WEST SUSSEX COUNTY COUNCIL CONSULTATION

TO:	Arun District Council FAO: Jessica Riches
FROM:	Stephen Gee WSCC - Highways Authority
DATE:	19 July 2022
LOCATION:	Land North of Water Lane and South of A27 Angmering BN16 4EU
SUBJECT:	A/90/22/DOC Approval of details reserved by condition imposed under A/40/18/OUT relating to conditions 23-Broadband provision, 33-risk associated with contamination and 39-bus access route.
DATE OF SITE VISIT:	n/a
RECOMMENDATION:	Further Information / Modification
S106 CONTRIBUTION TOTAL:	n/a

Title:
**Condition 39
Bus Route Construction
Typical Detail**

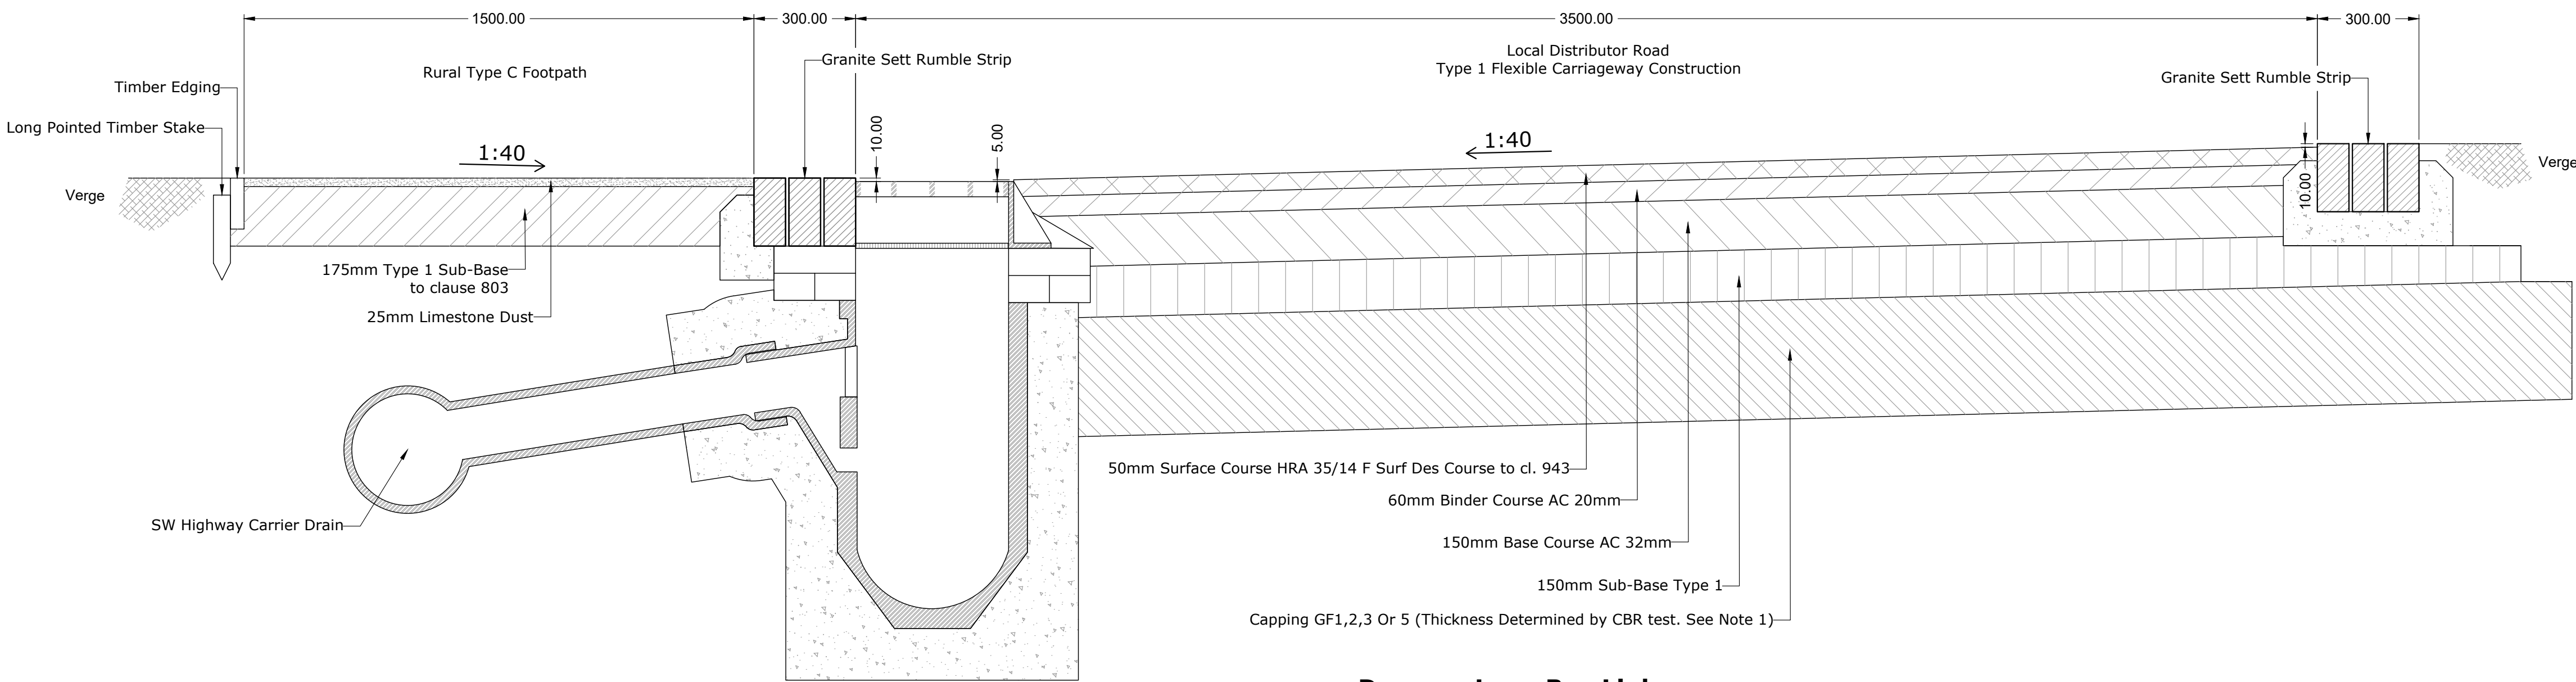
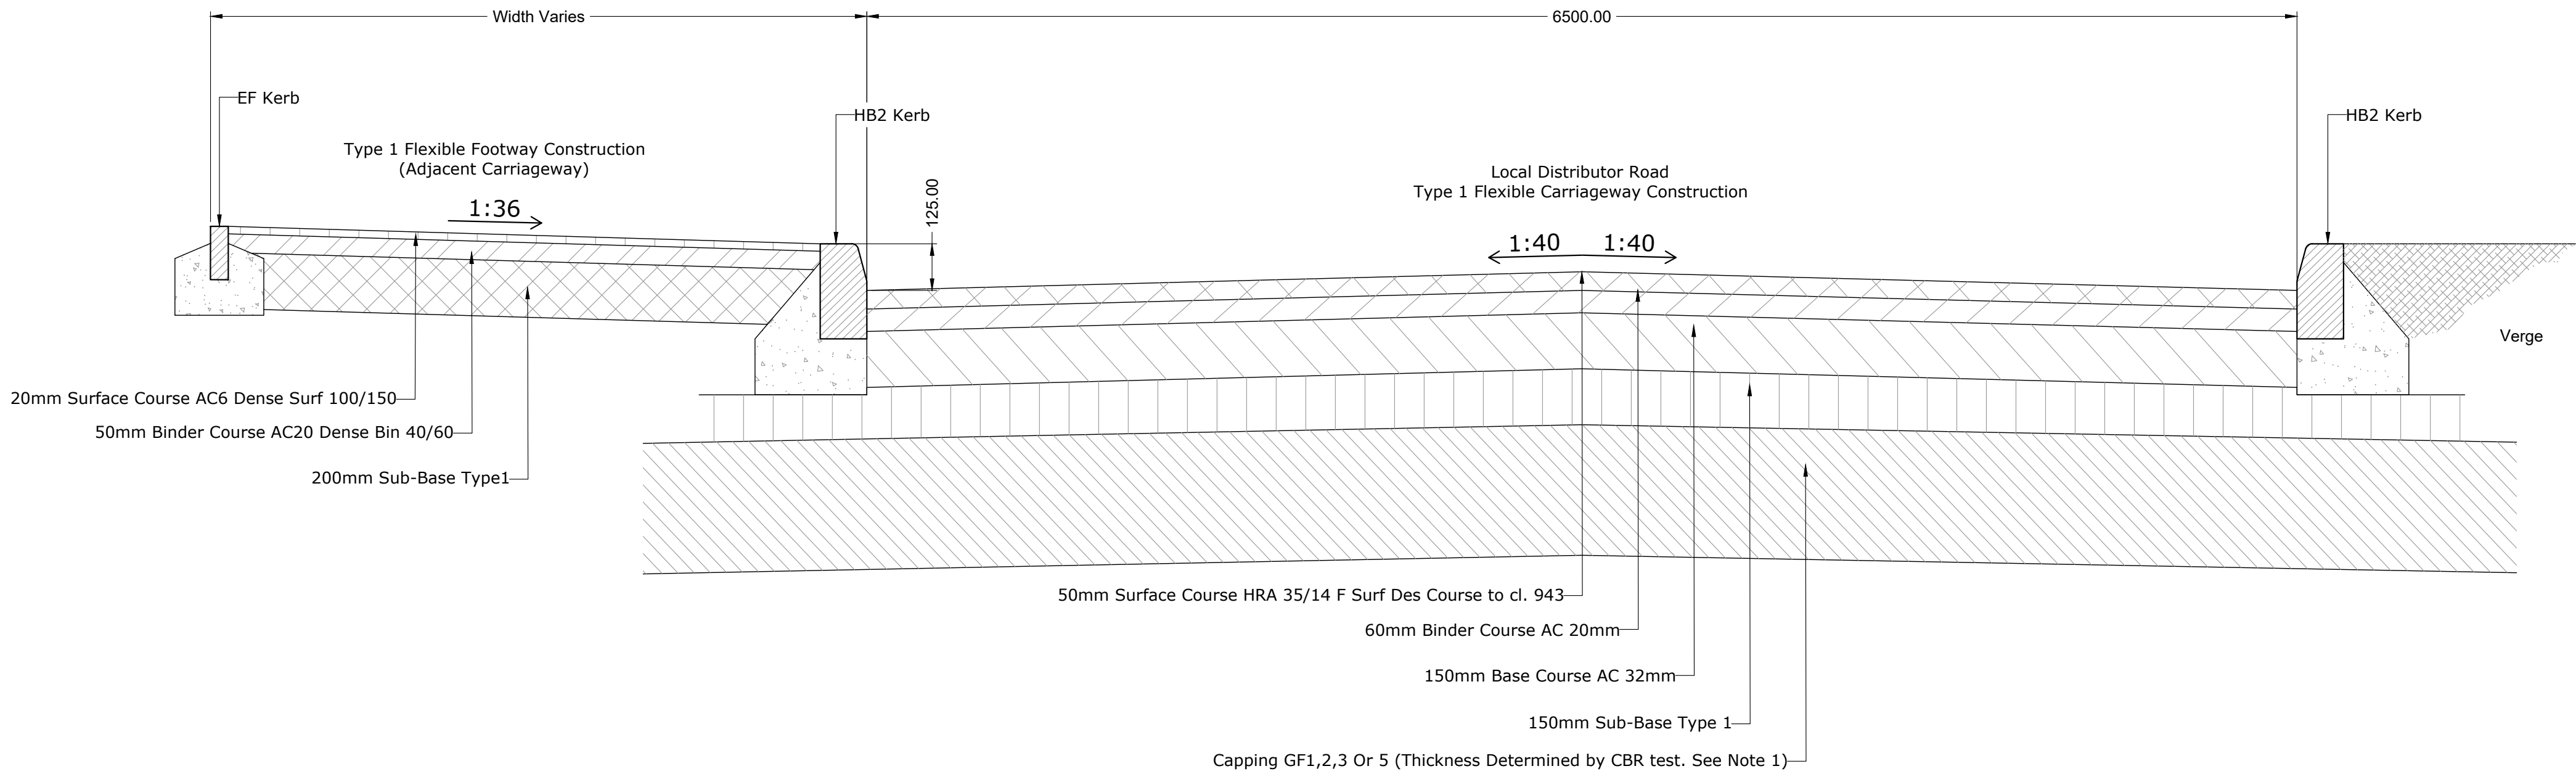
The applicant proposes a 3.5m wide shared surface with adjacent 1.5m wide footway provided along the link to Dappers Lane where the use of ANPR will restrict its use to buses/emergency services and cyclists. The bus gate will allow two way movements, however is not wide enough to allow these concurrently. To allow this to happen a loop and traffic signal arrangement will be provided.

The internal development only provides for a single bus stop on the south bound length. A second stop should be provided on the north bound length of the spine road.

A second bus stop would be required to be provided and location of signal heads to be provided shown.
